**WELWYN HATFIELD BOROUGH COUNCIL  
EXECUTIVE DIRECTOR - PLANNING, PUBLIC PROTECTION AND GOVERNANCE**

**DELEGATED APPLICATION**

**Application No:** 6/2022/0558/LB  
**Location:** The Old Vicarage Vineyards Road Northaw Potters Bar EN6 4NZ  
**Proposal:** Erection of single storey rear extension to grade II listed property following partial demolition of existing double garage to single.  
**Officer:** Ms Ashley Ransome

**Recommendation:** Refused

| DRAWING No: | PRO51/P_PL01_A1 | REV: | A | Scale: | 1:100@A1 | Client: | Mr & Mrs Fuller |

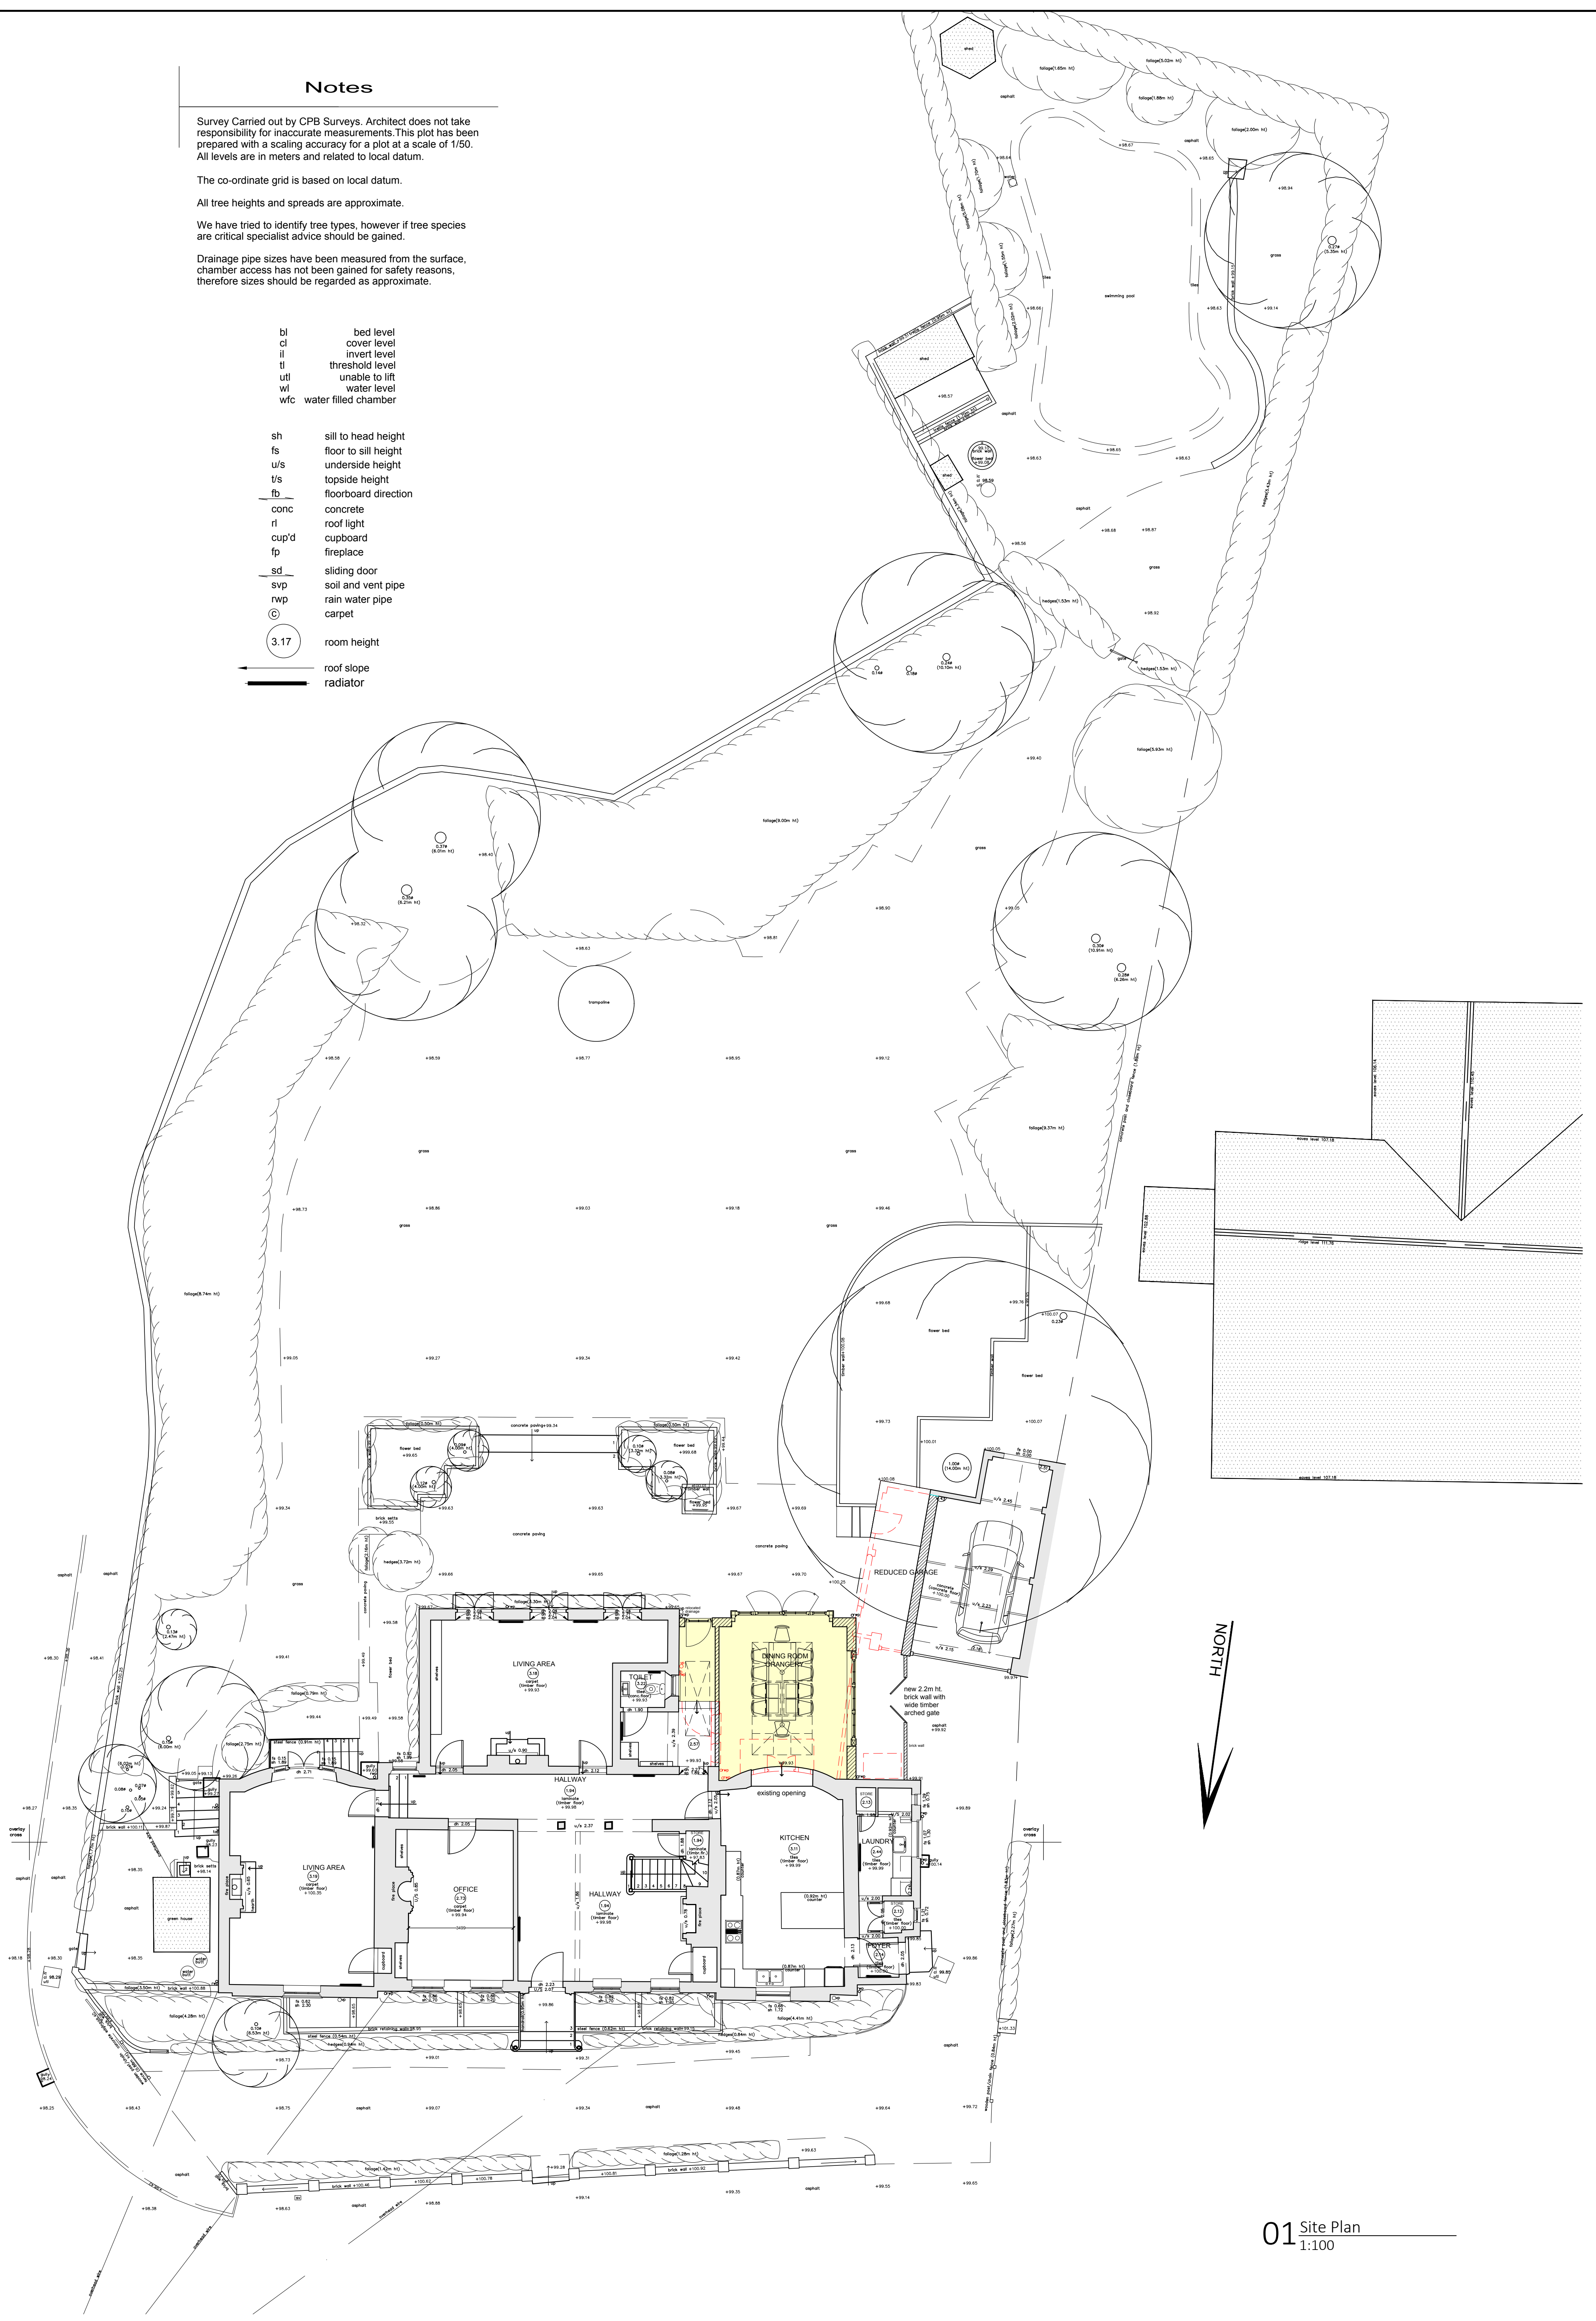
An in-principle objection has been received from the Council’s Heritage Consultant. It is considered that whilst the two storey extensions are later additions, these date from the 19<sup>th</sup> century with the design intentionally creating a symmetrical appearance which is an important part of the attractive appearance of this rear elevation. A single storey rear extension in the proposed location would not only alter the symmetrical appearance but it would diminish the understanding of the design intention of the 19th century. Therefore, an extension in this location is not considered acceptable as it would harm the character and appearance of the listed building.

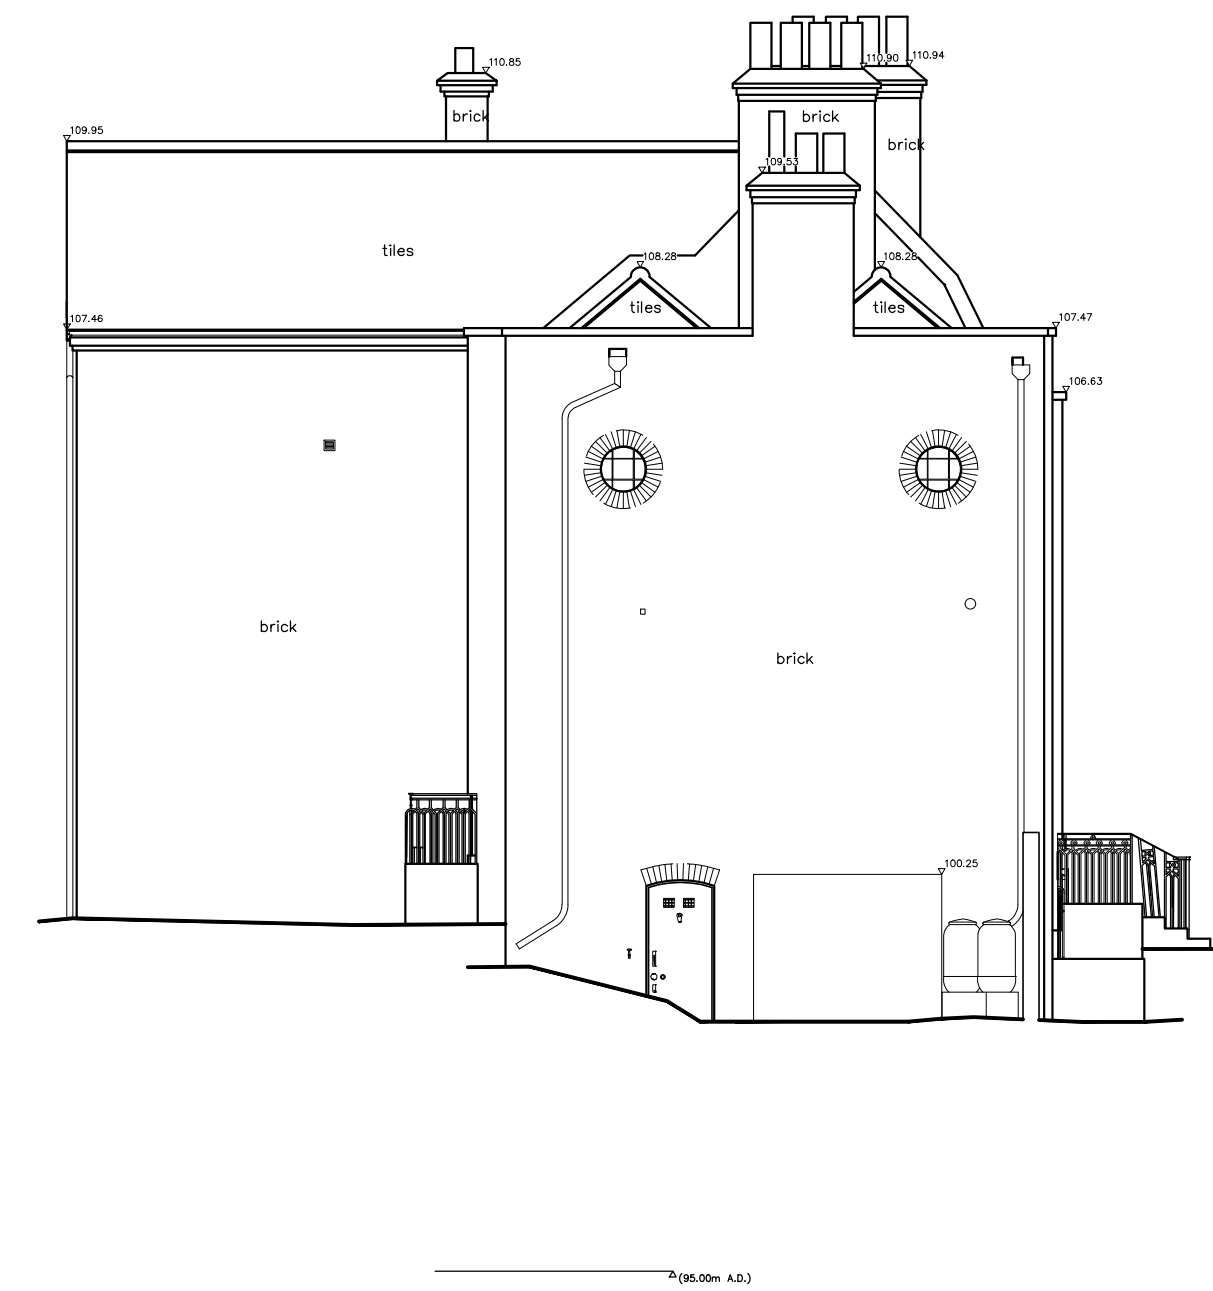
1. The proposed development would materially harm the Grade II Listed Building, and whilst this is considered to result in less than substantial harm, public benefits to outweigh the identified harm do not exist. As such the proposal is contrary to the Welwyn Hatfield District Plan; Draft Local Plan Policy SADM15; the Planning (Listed Buildings and Conservation Areas) Act 1990; and the National Planning Policy Framework.
